KIRKLEES METROPOLITAN COUNCIL INVESTMENT & REGENERATION SERVICE

DELEGATED DECISION TO DETERMINE PLANNING APPLICATIONS

Reference No:	2025/62/93345/W
Site Address:	257, Birkby Road, Birkby, Huddersfield, HD2 2DW
Description:	Replacement of roof including increasing height of eaves and ridge, erection of two storey side and single storey front extensions, demolition of existing garage and erection of detached garage to front, widening of existing access with associated surfacing and works
Recommending Officer:	Joanna Rednall

DECISION – CONDITIONAL FULL PERMISSION

Drawn DRH
Date Sept 2025
Scales 1: 100 1: 500 @ A2
Drawing No. 2582 - 0301 - R06

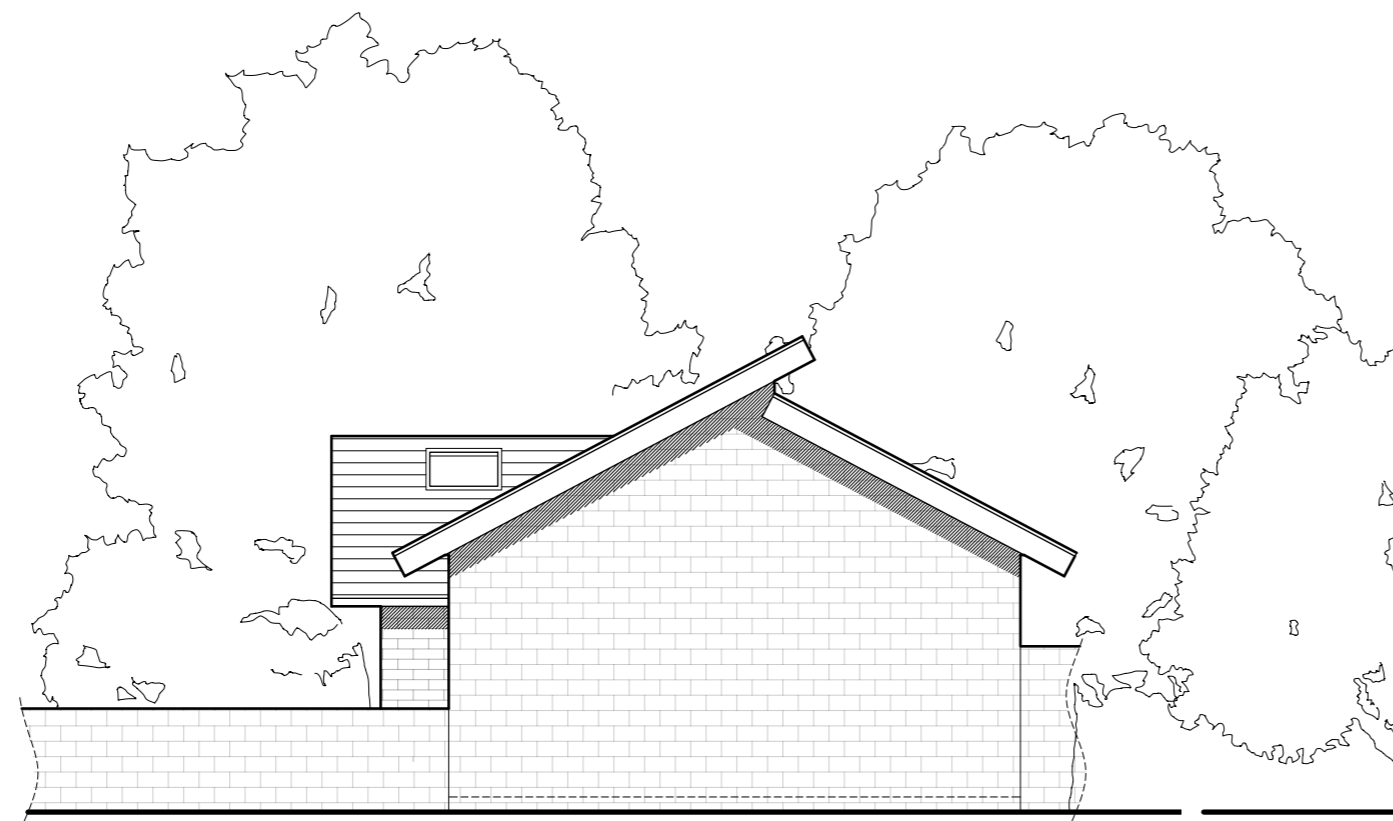
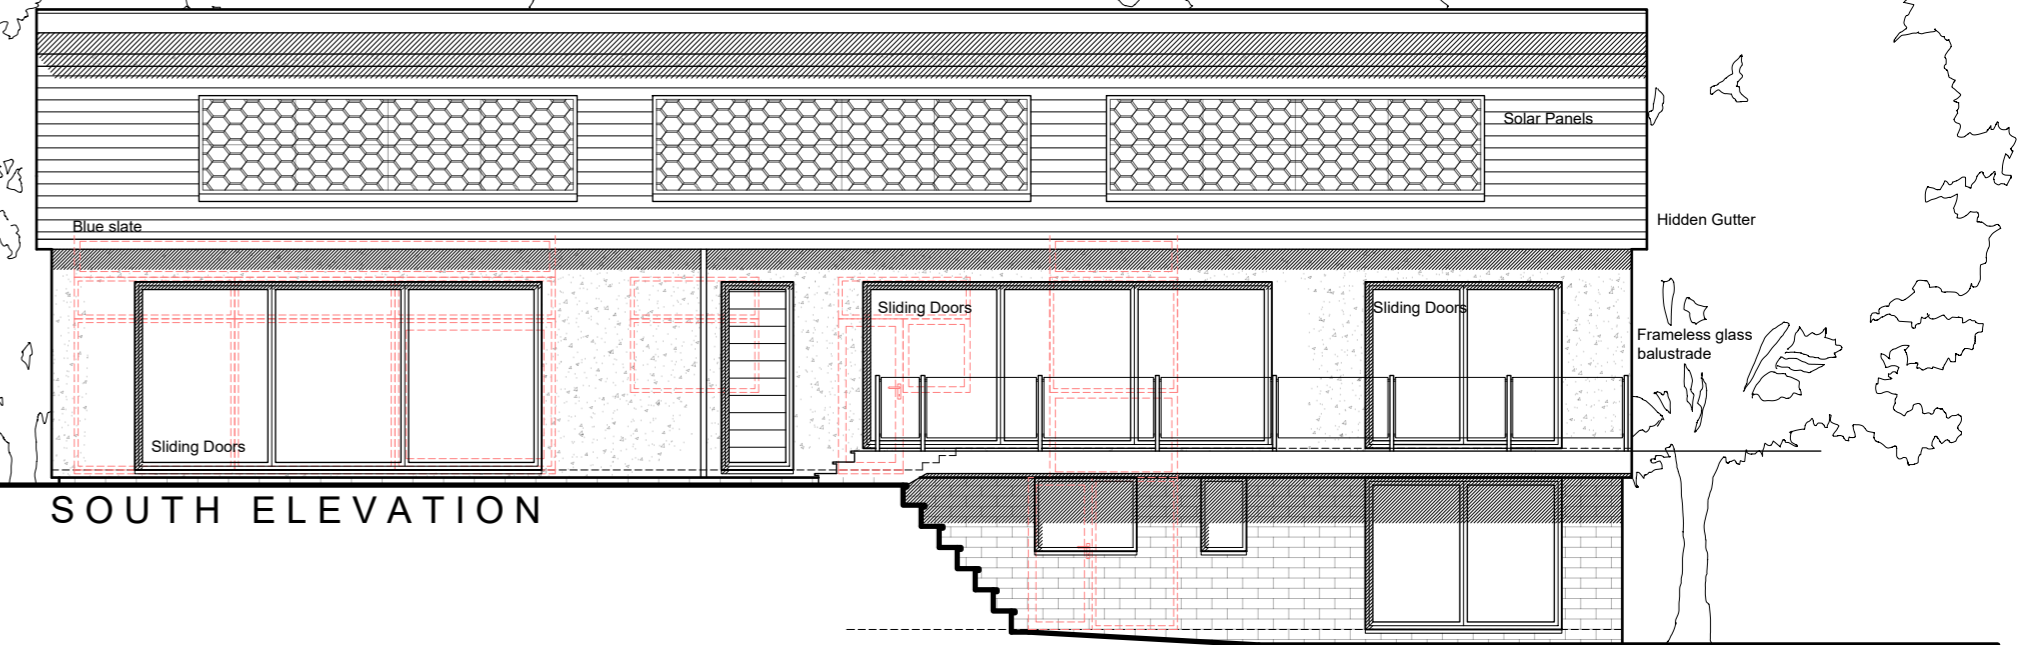
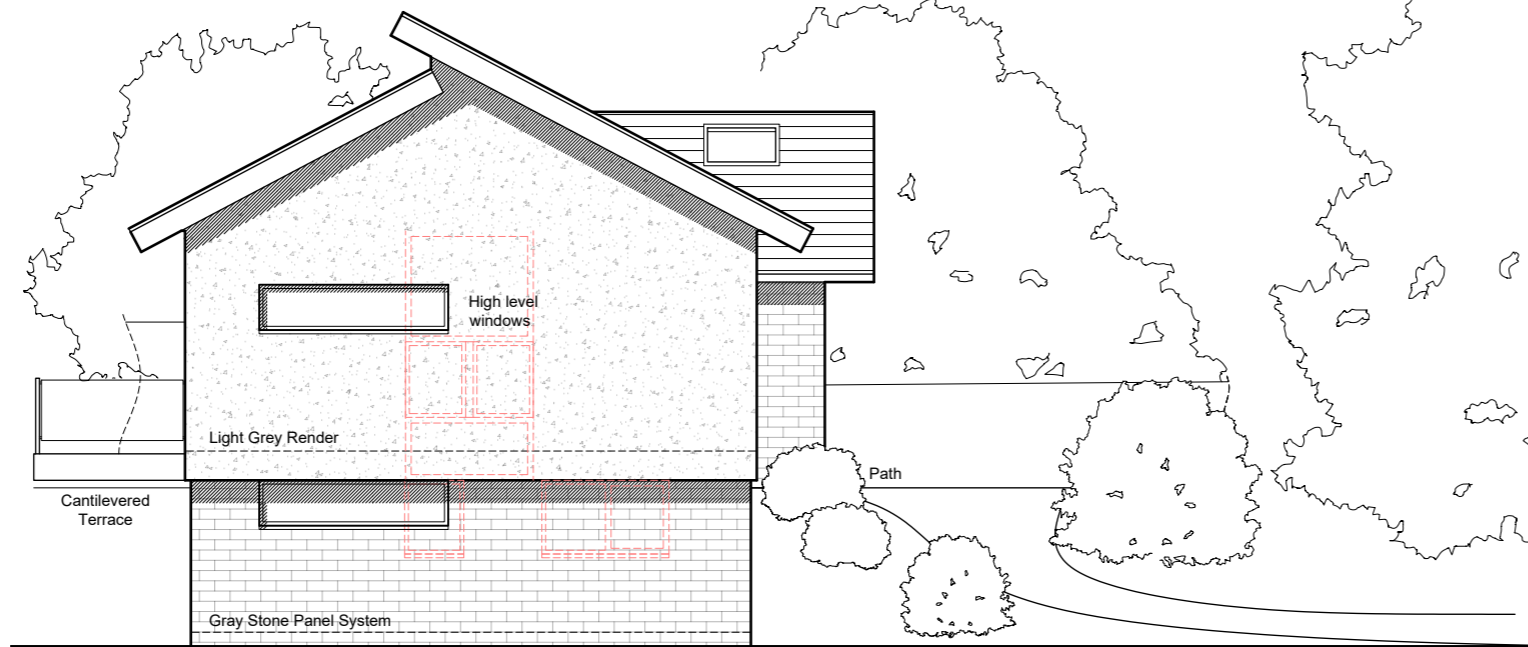
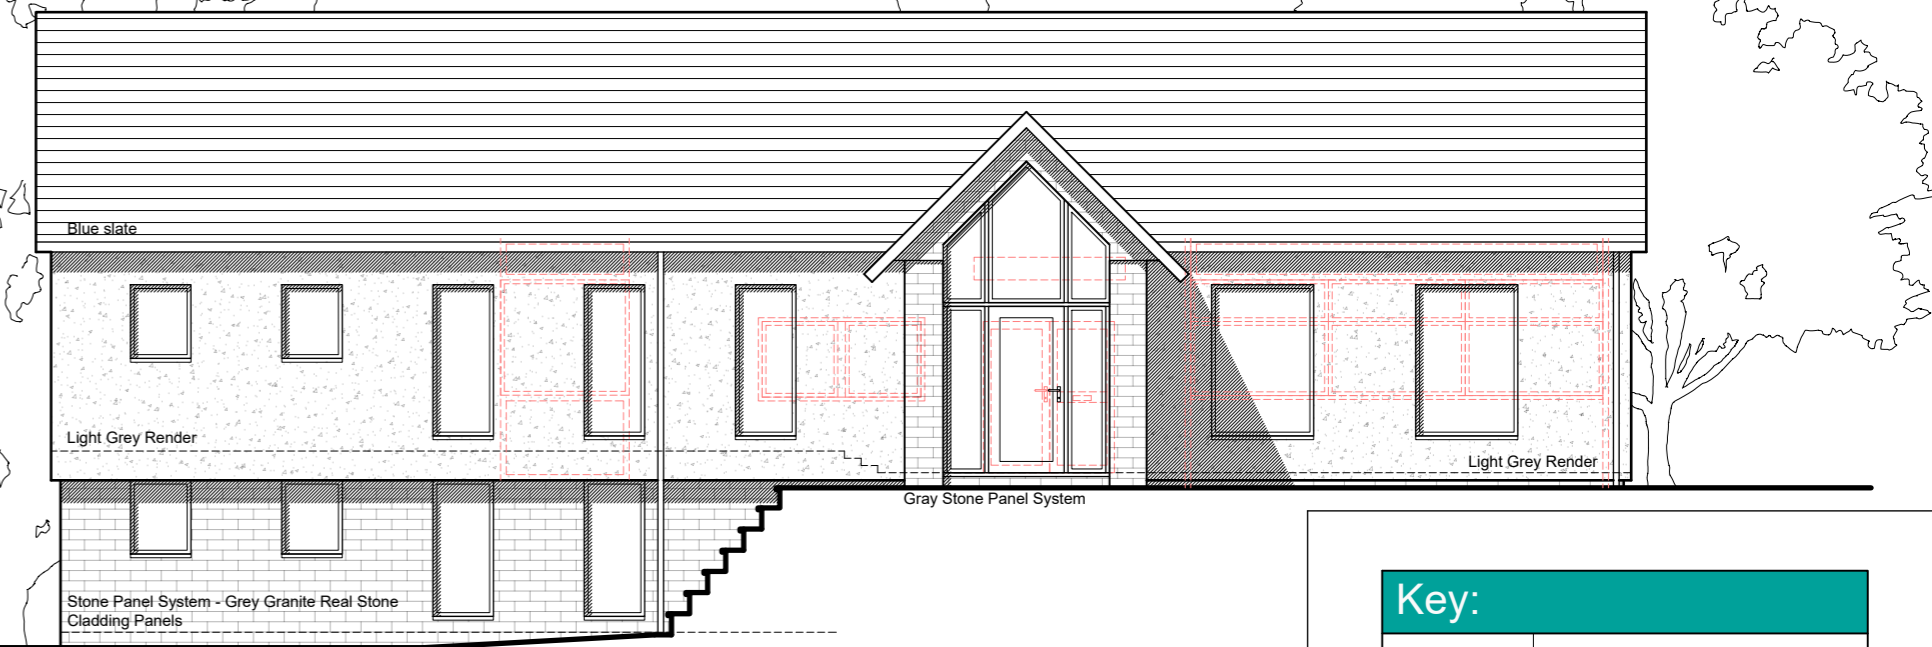
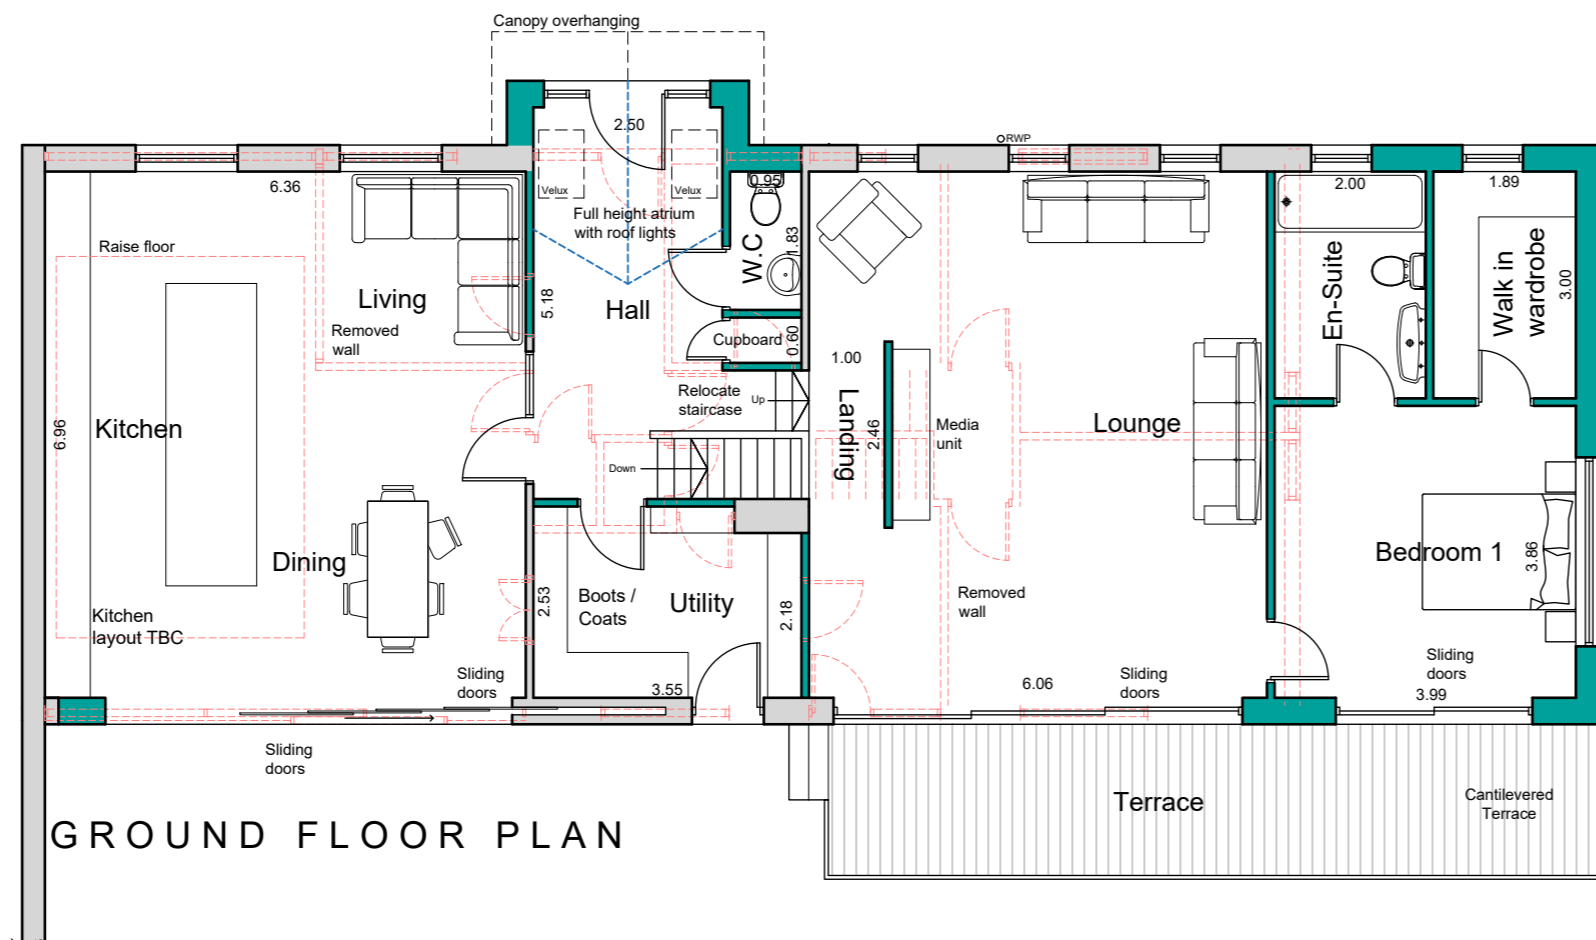
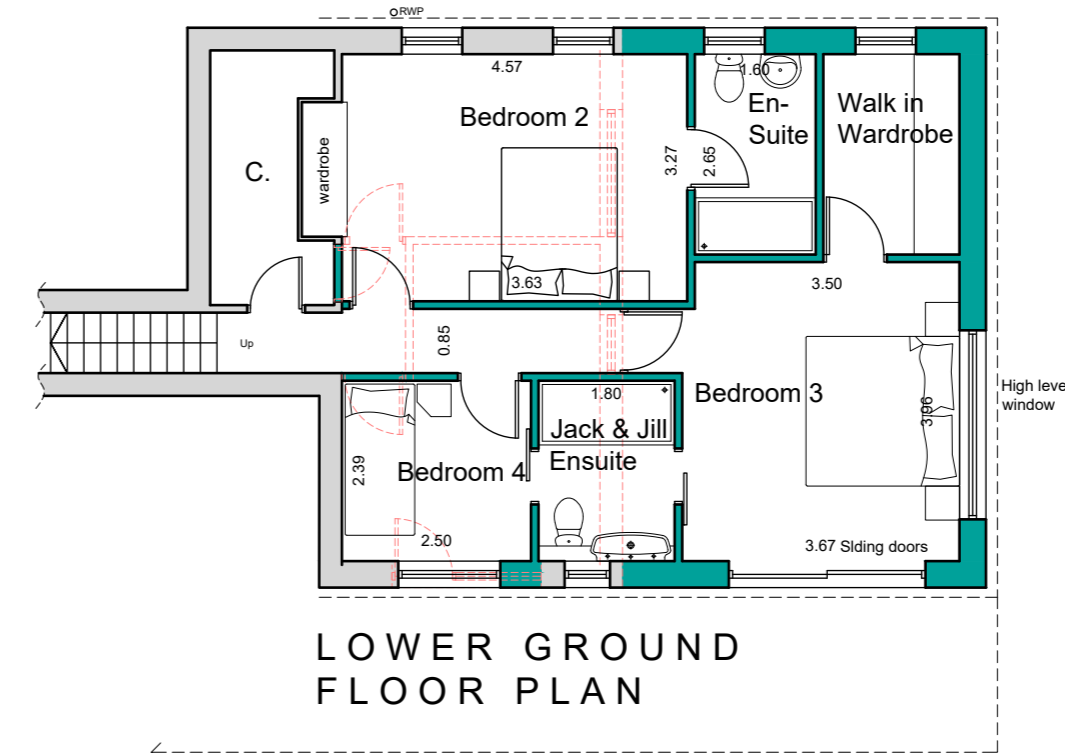
The proposed two storey side extension does not extend across the full width of the side garden and retains a clear separation from the side boundary. A minimum gap of approximately 1.6 metres would be maintained, increasing to around 2.5 metres due to the oblique angle of the building in relation to the boundary. This arrangement would preserve a sense of openness and maintain visual separation between built forms, ensuring that the extension would not appear unduly dominant or result in a sense of enclosure when viewed from neighbouring sites or from wider public vantage points along Birkby Road.

Whilst the extension is not set back from the principal elevation, this is considered acceptable in the context of the application site. The proposed split-level design responds to the existing topography and would reduce the perceived bulk and prominence of the structure. As such, the extension would not appear overly prominent within the street scene. The proposed external materials, comprising render and stone, are considered appropriate and would reflect the established material palette of the surrounding area, thereby ensuring the proposal integrates with the host.

In addition, two windows are proposed within the eastern elevation serving bedrooms. These are designed as high-level windows and, when taken together with the existing boundary screening, would not result in harmful overlooking towards the occupants of No.255. On this basis, it is considered that the proposal would maintain an acceptable level of privacy for neighbouring properties. These bedrooms are served by other windows with the high level windows being a secondary source of light.

In terms of overshadowing, overbearing impact, and loss of light, the proposal would introduce additional built form to the eastern side of the application site. It is acknowledged that No.255 is a single-storey property and that the proposed development would present as a two-storey addition when viewed from this direction. However, the relationship between the properties is already moderated by the presence of established boundary vegetation, including hedging and trees, which provide a degree of screening. Furthermore, the elevation of No.255 facing the application site is largely blank, with no primary windows affected. Taking these factors into account, it is considered that the proposal would not result in a significant increase in overbearing impact or lead to unacceptable levels of overshadowing or loss of light beyond the existing situation.

Drawing No. 2582 - 0302 - R04

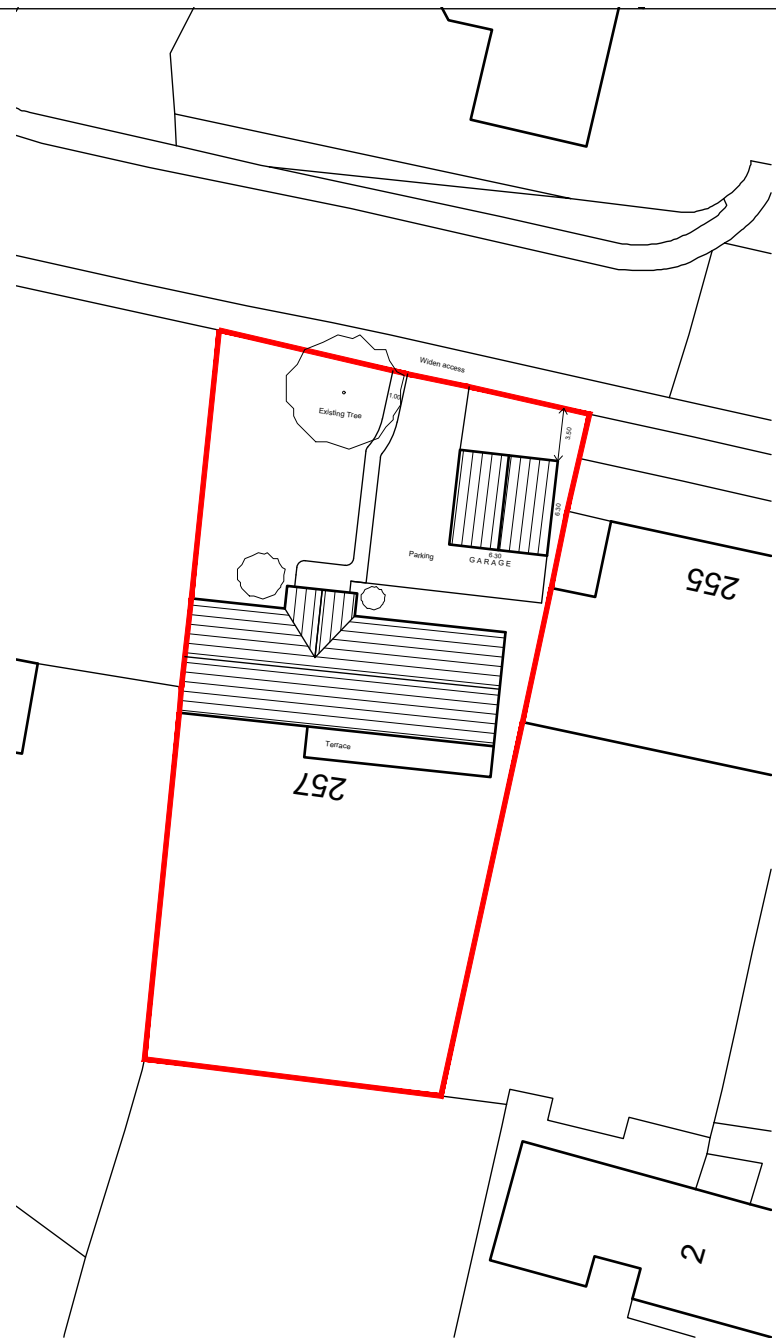
Officers raised concerns with the applicant's agent regarding the siting of the proposed garage. Amended plans received on 27 February reposition the garage further away from the highway. These revisions were considered acceptable and the application has therefore been progressed to determination on the basis of the amended plans.

With regard to the established building line, the garage would be located to the front of the dwelling, and would project beyond No.255, the neighbour to the side. Nevertheless, when viewed within the context of the wider street scene along Birkby Road, the building line is not uniform and exhibits a degree of variation. While the proposed garage would extend beyond the building line to the east, the pattern of development to the west is more irregular, and therefore the proposal would not appear unduly prominent or harmful. Furthermore, the garage would be set back approximately 3.5 metres from the street, which would further reduce its visual impact. The proposed garage has been designed with a pitched roof to match the style of the main

The agent has also provided justification for the proposal in correspondence dated 27 February, stating: *“There is no material visual harm. The garage will match the materials of the main dwelling, ensuring it remains subordinate and in keeping. An existing boundary wall already screens the site from the road, with mature hedging above reaching approximately 6–8 feet in height. The structure will therefore be largely concealed from public view.”*
